15 December 2015

Mr Ashley Cheong
Department of Planning and Environment
GPO Box 39
Sydney NSW 2001

Remediation, Renewal and Adaptive Re-Use of Campbell's Stores, The Rocks and Variation to the Sydney Cove Redevelopment Authority Scheme – Notice of Exhibition

Drawing Title  
**SITE PLAN**  
**PROPOSED**  
 JPW Project Number  
**12006**  
 Drawing Status  
**EA**  
 Drawing Number  
**EA-A-002**  
 Revision  
**B**

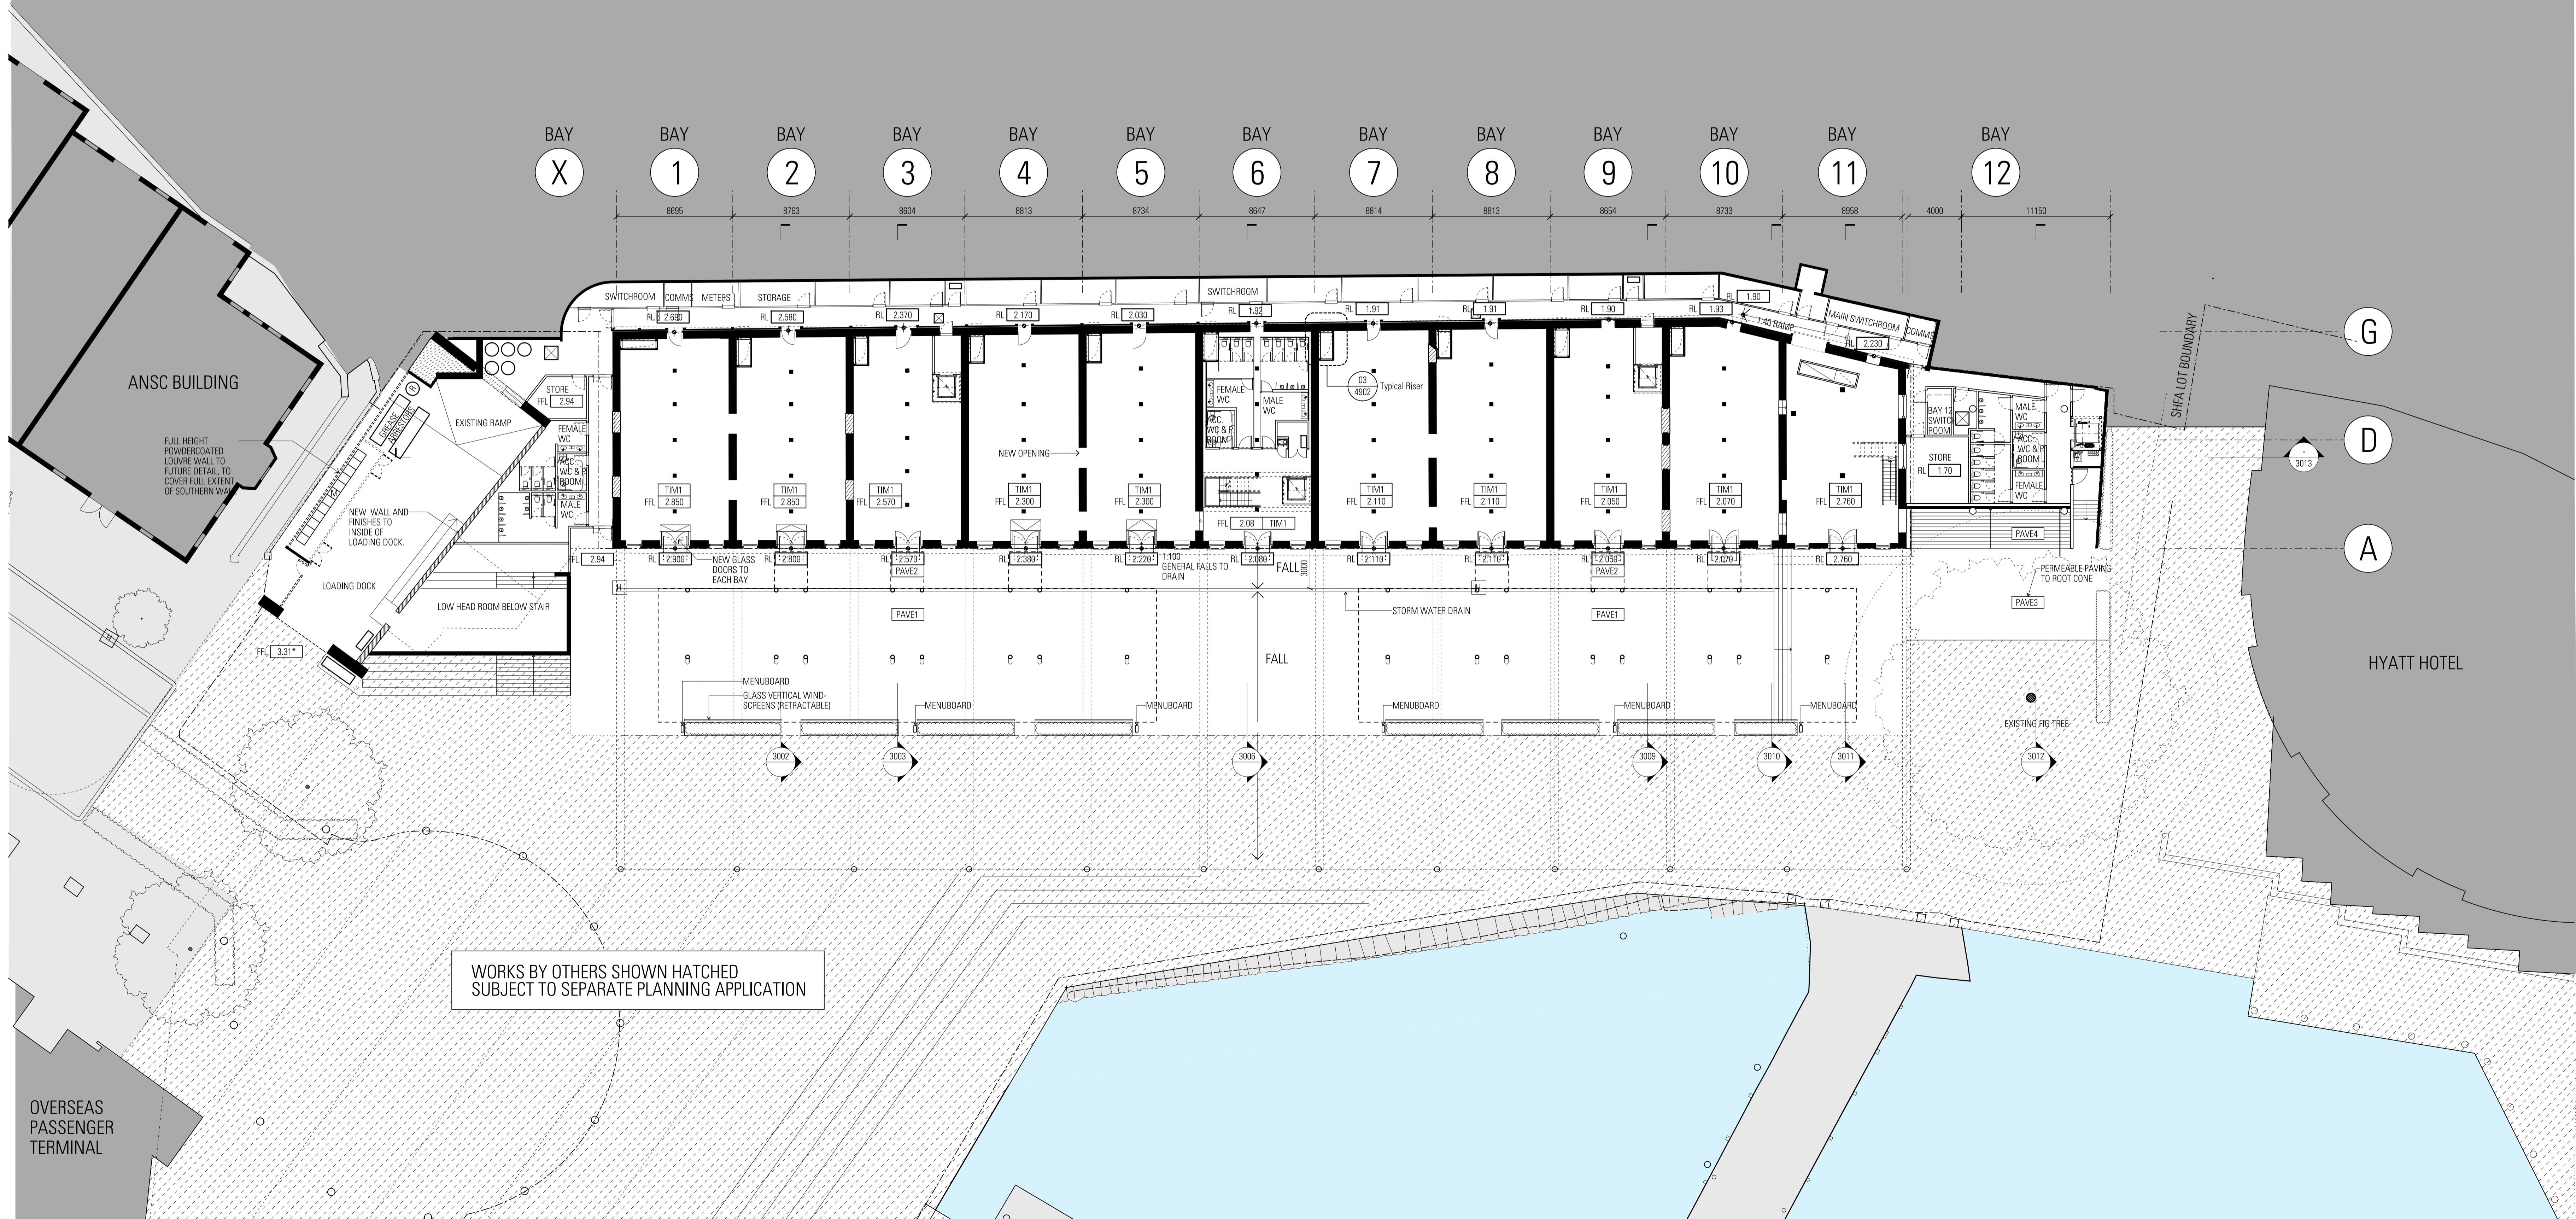
- The DA proposes a new LED signage element in Bay X, shown on EA-A-1002. This appears to be on land owned by the Port Authority.
- The proposed views of Photomontages 'Camera 5a' and 'Camera 5b' include works (e.g. footpath widening, narrowing of the Port Authority's access road to the OPT) that encroach on Port Authority land and which, according to EA-A-0002, are not part of this application.

Drawing Title  
**HICKSON ROAD LEVEL 01 PLAN**  
Drawing Number  
**12006**  
Drawing Status  
**EA**  
Drawing Number  
**EA-A-1002**  
Revision  
**B**

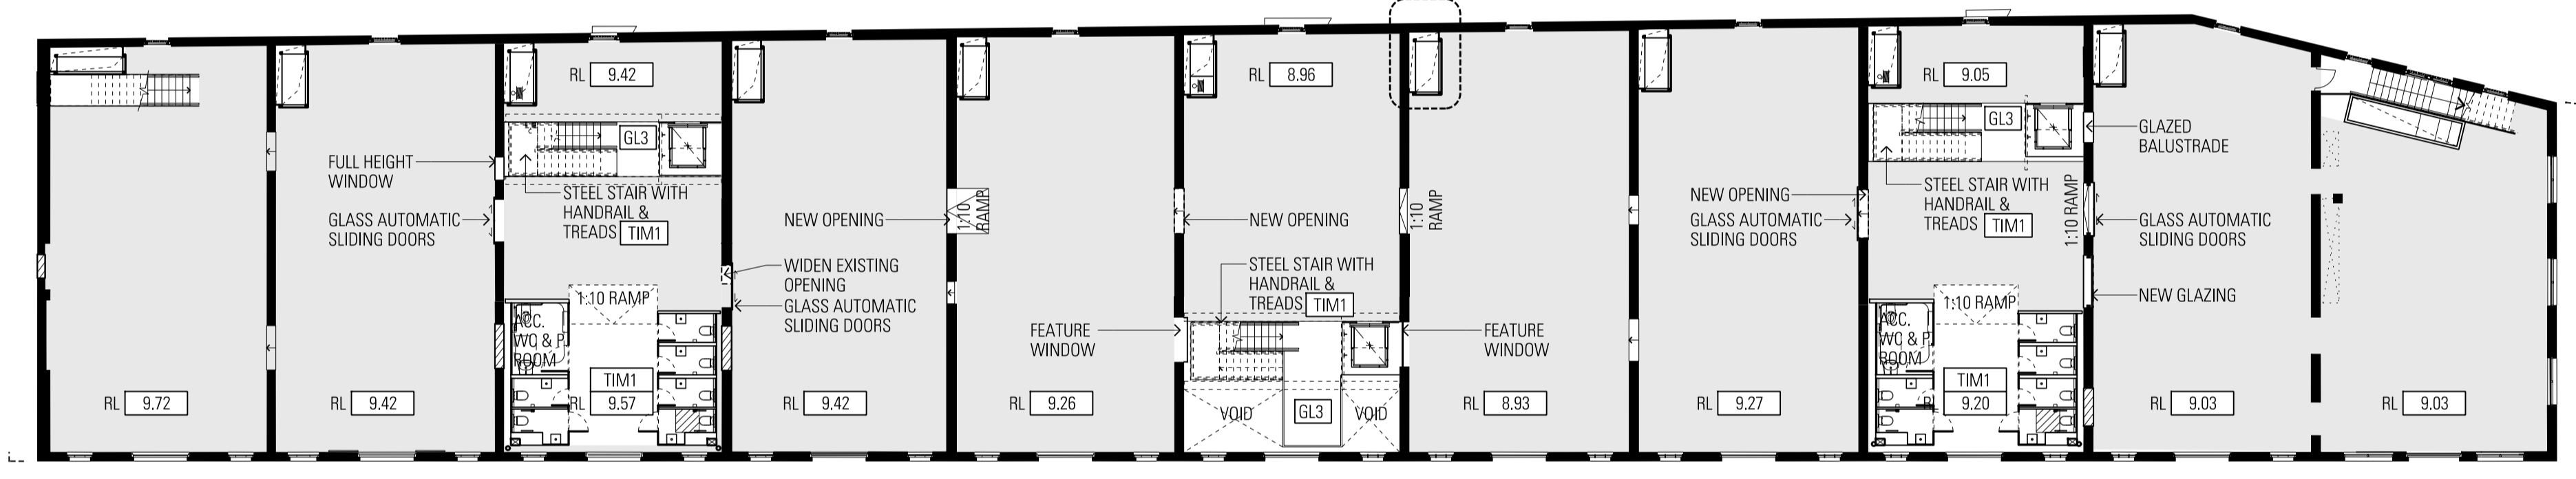
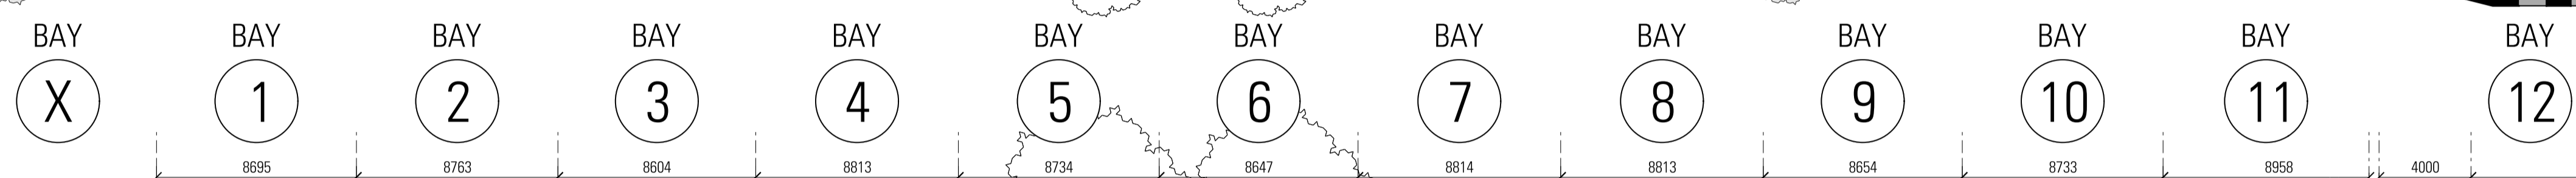
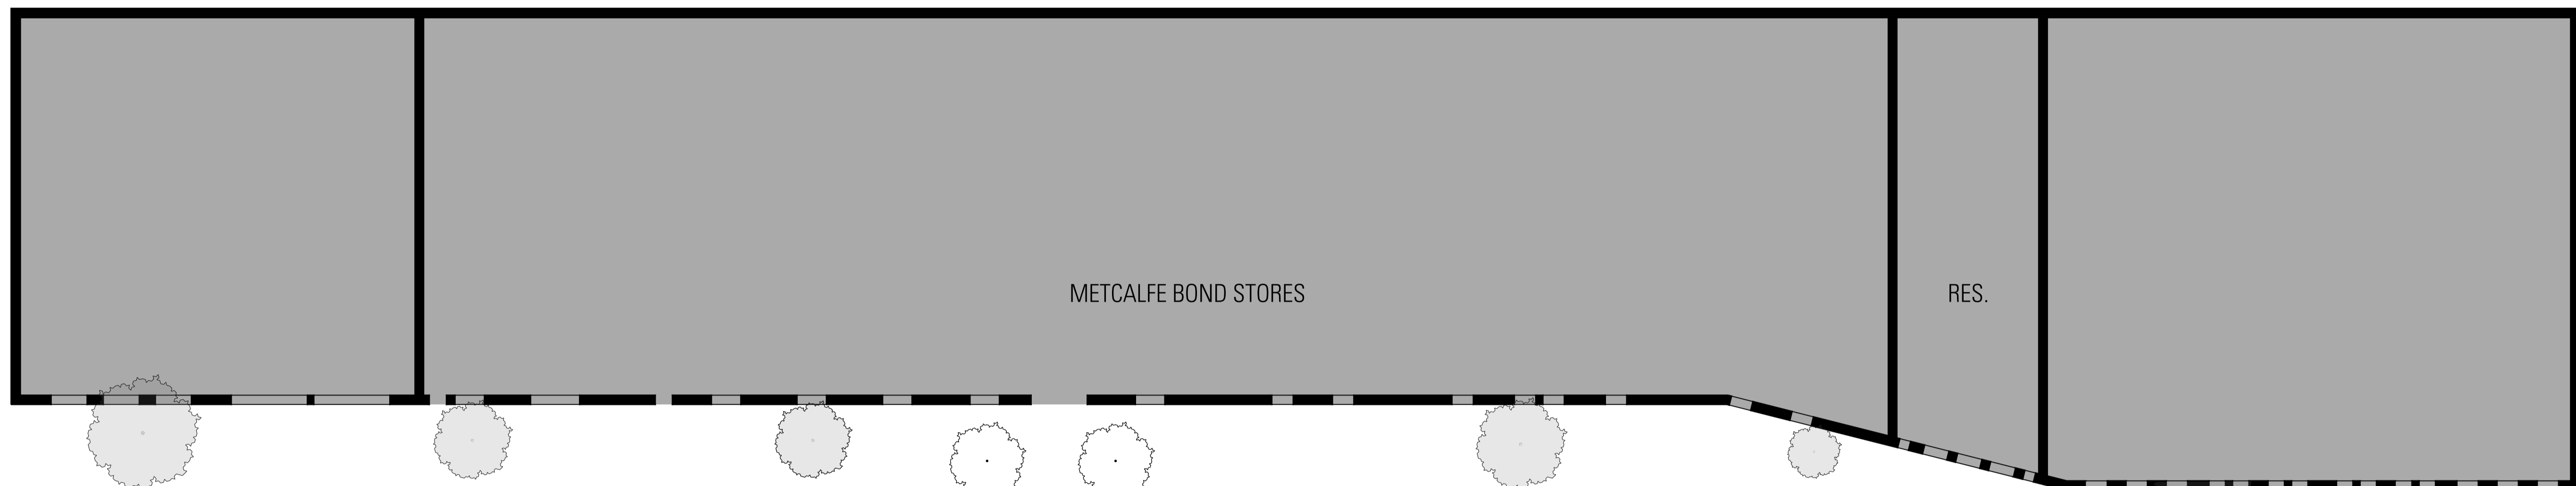
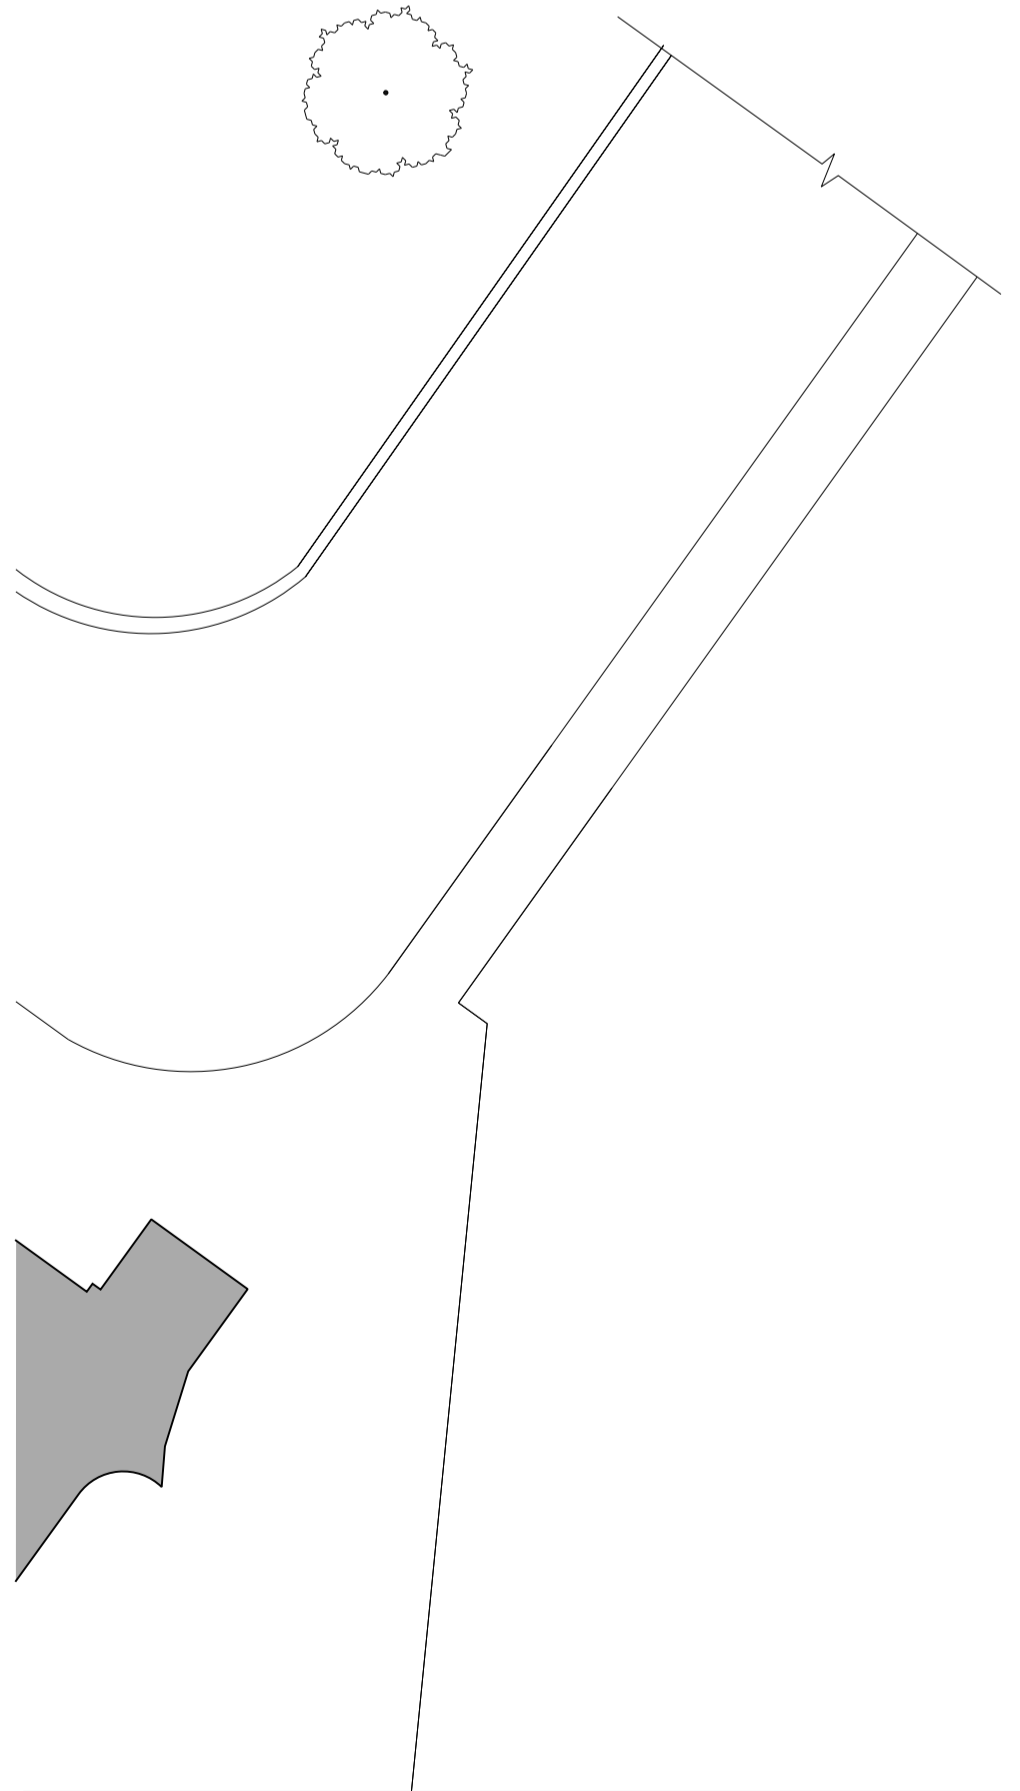
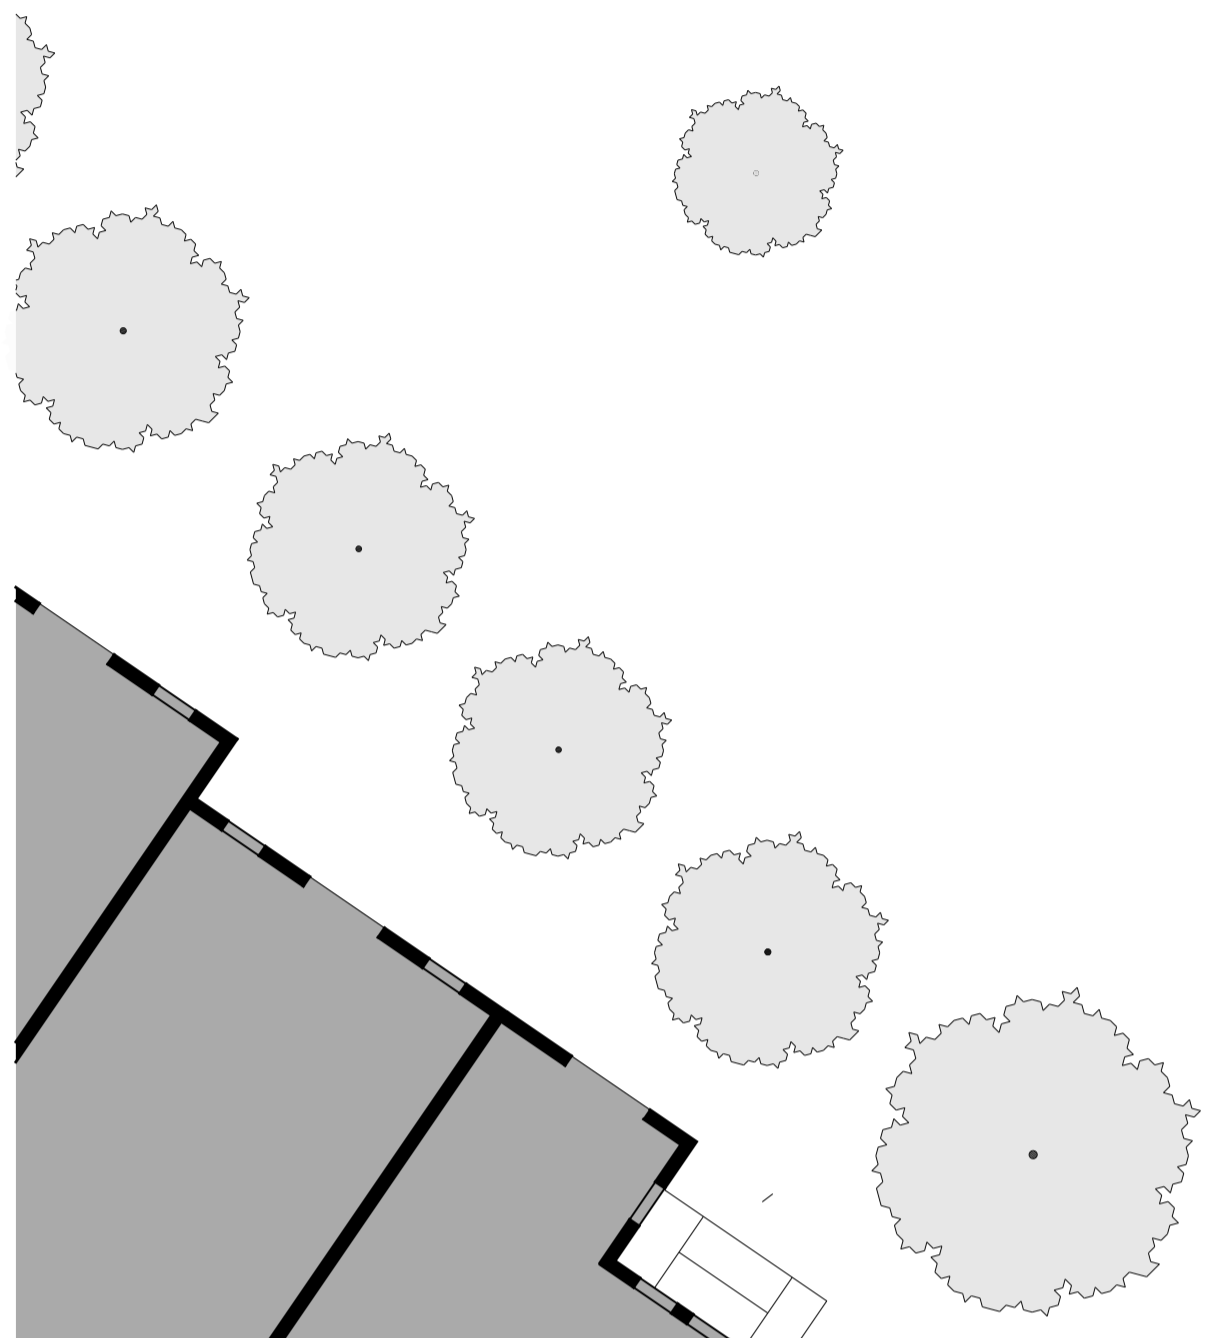
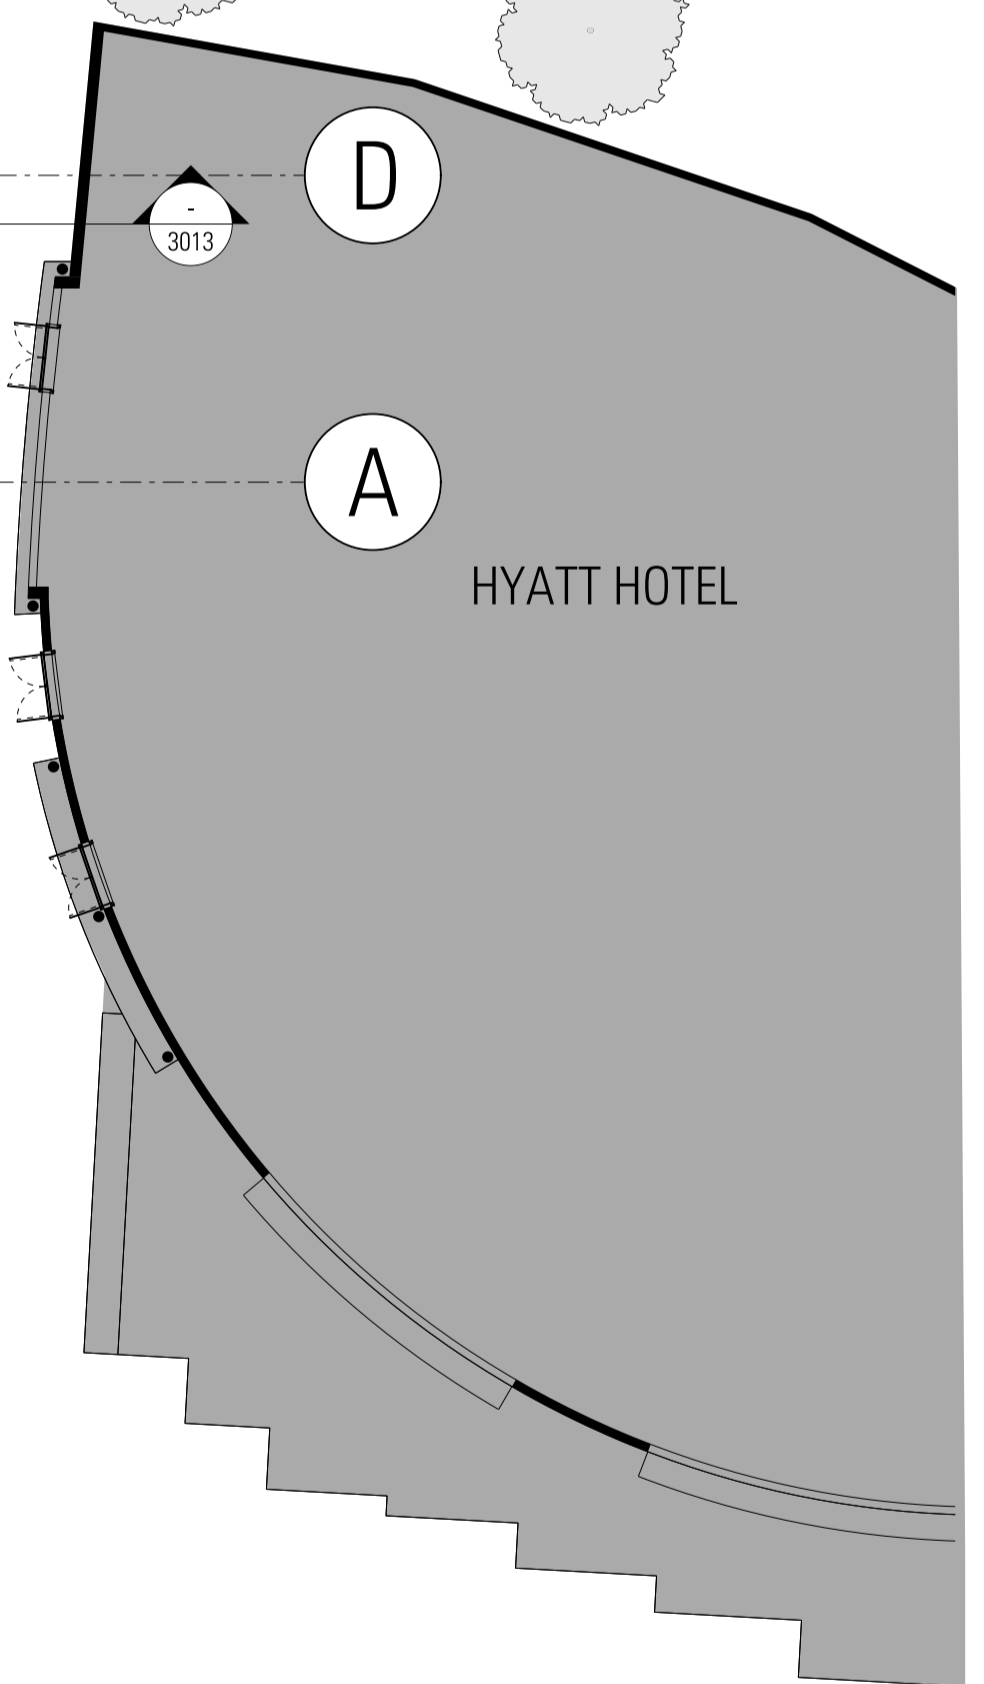
With respect to the proposed digital sign, the Port Authority does not consent to its proposed placement at this stage, which appears to be on Port Authority owned land. We feel that further discussions are required between the relevant stakeholders, including the Port Authority, and consideration should be made to rationalise and integrate precinct signage. It is noted that this area has been previously highlighted by the Port Authority as a potential location for precinct and OPT-related wayfinding signage.
